Our ref: ARDEX Warehouse and Manufacturing Facility (SSD-25725029)

31 August 2022

Subject: Request for Additional Information

Attachment: Proposed Elevations Plan

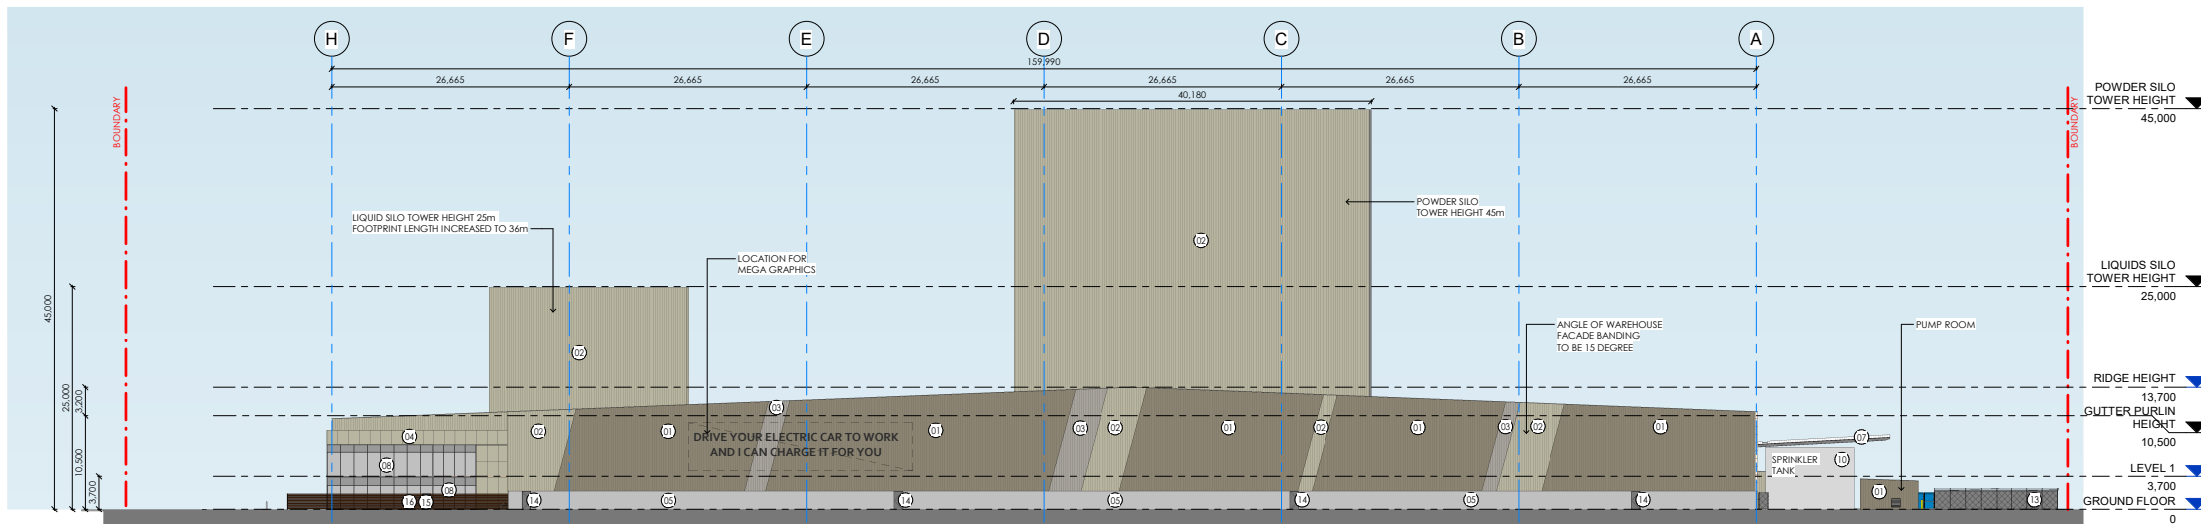
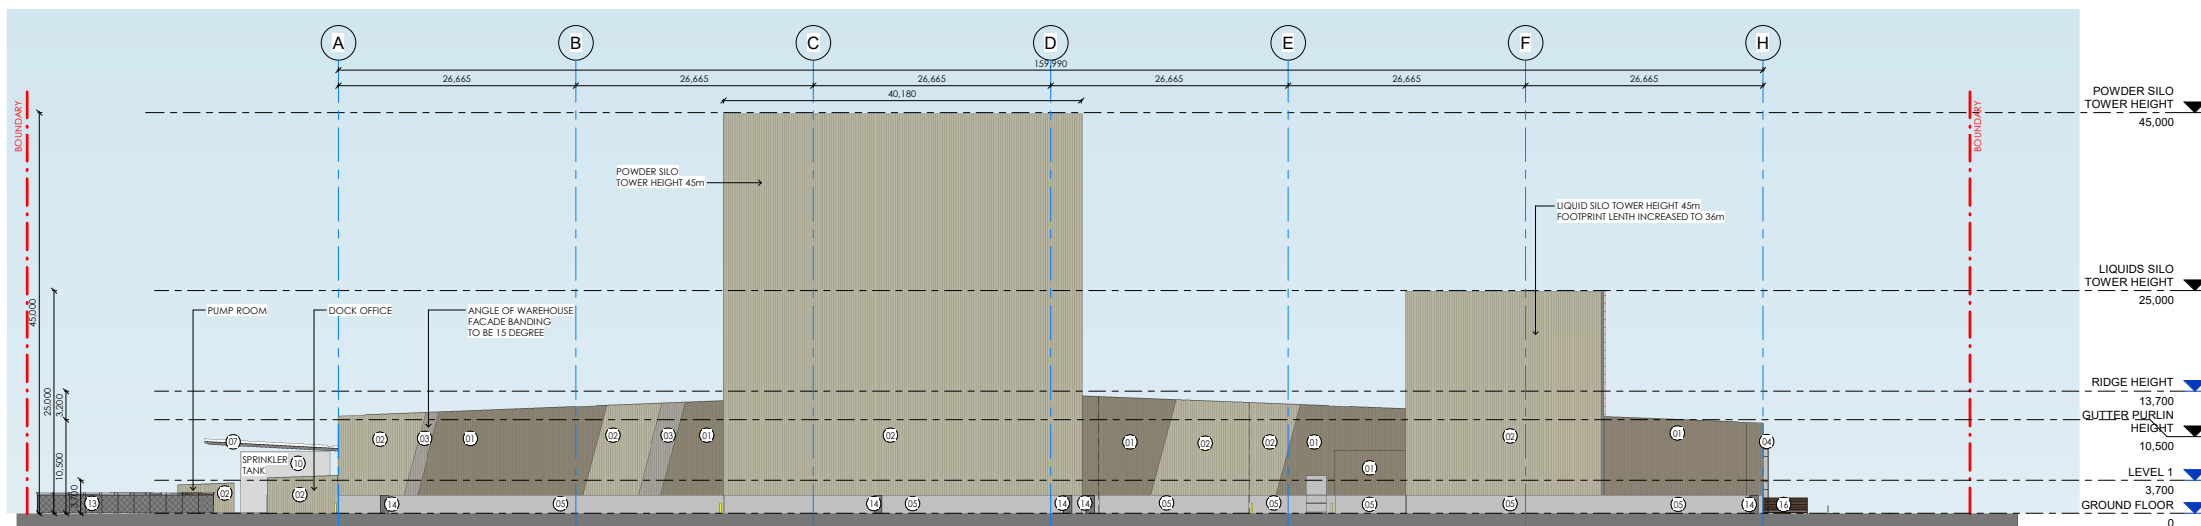
1. The updated Noise and Vibration Impact Assessment submitted with the RtS proposes additional noise mitigation structures which are not shown on the architectural plans. Please provide updated architectural plans that include the proposed noise mitigation measures.
